RIBA Stage 3 - Planning
Response to Planning Consultees

| Application No | 2025/1029 |
| Proposal | Proposed subdivision of existing industrial building into 8 workshop units (Use Class E(g)/ B2) with external alterations including partial demolition of the existing building, and refurbishment of existing office block. |
| Address | Unit 1 Plot 15, Carlton Industrial Estate Plot 4 Albion Road, Carlton, Barnsley, S71 3HW |

Proposed Building and Site Plan
Scale 1:200

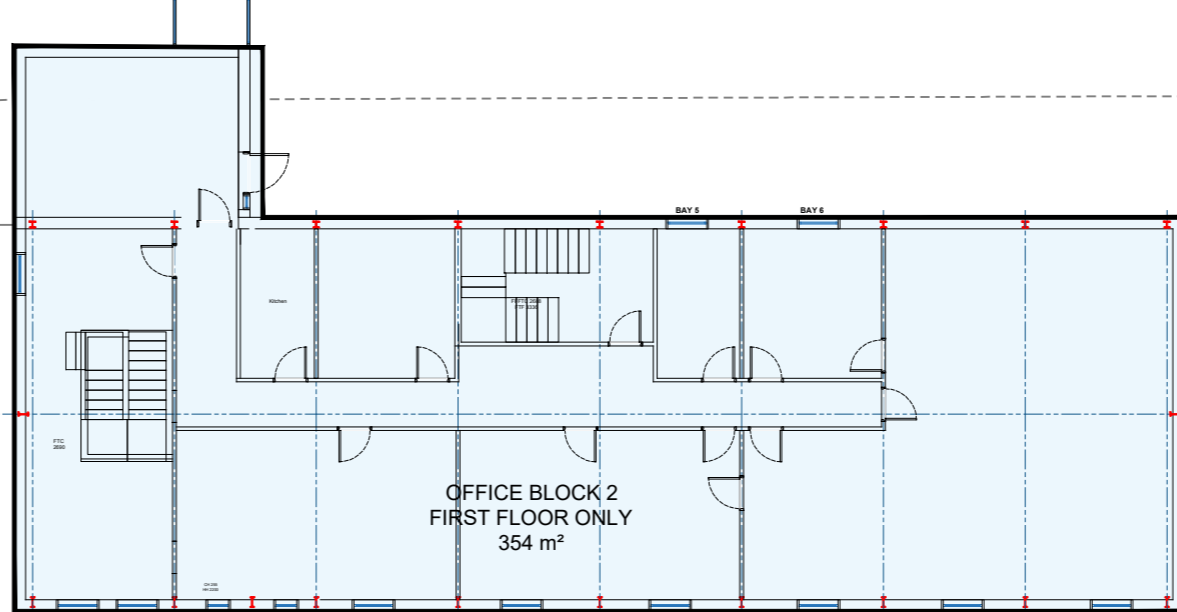
In terms of providing clarity on parking provision for the site we can confirm the on site parking that will be allocated to each unit as requested by Highways Development Control.

Units 1,2,3,4 and 5 will be allocated 5 spaces each on site. Unit 6 will be allocated 7 spaces. Unit 7 will be allocated 11 spaces and unit 8 will be allocated 3 spaces on site. This amounts to the proposal confirming that there will be parking provision for a minimum of 46 spaces within the site for the units within accordance to Barnsley’s parking standards. There will be more room for spaces within the site if needed.

The site will provide a minimum of 46 allocated off street parking spaces within the site for the units.
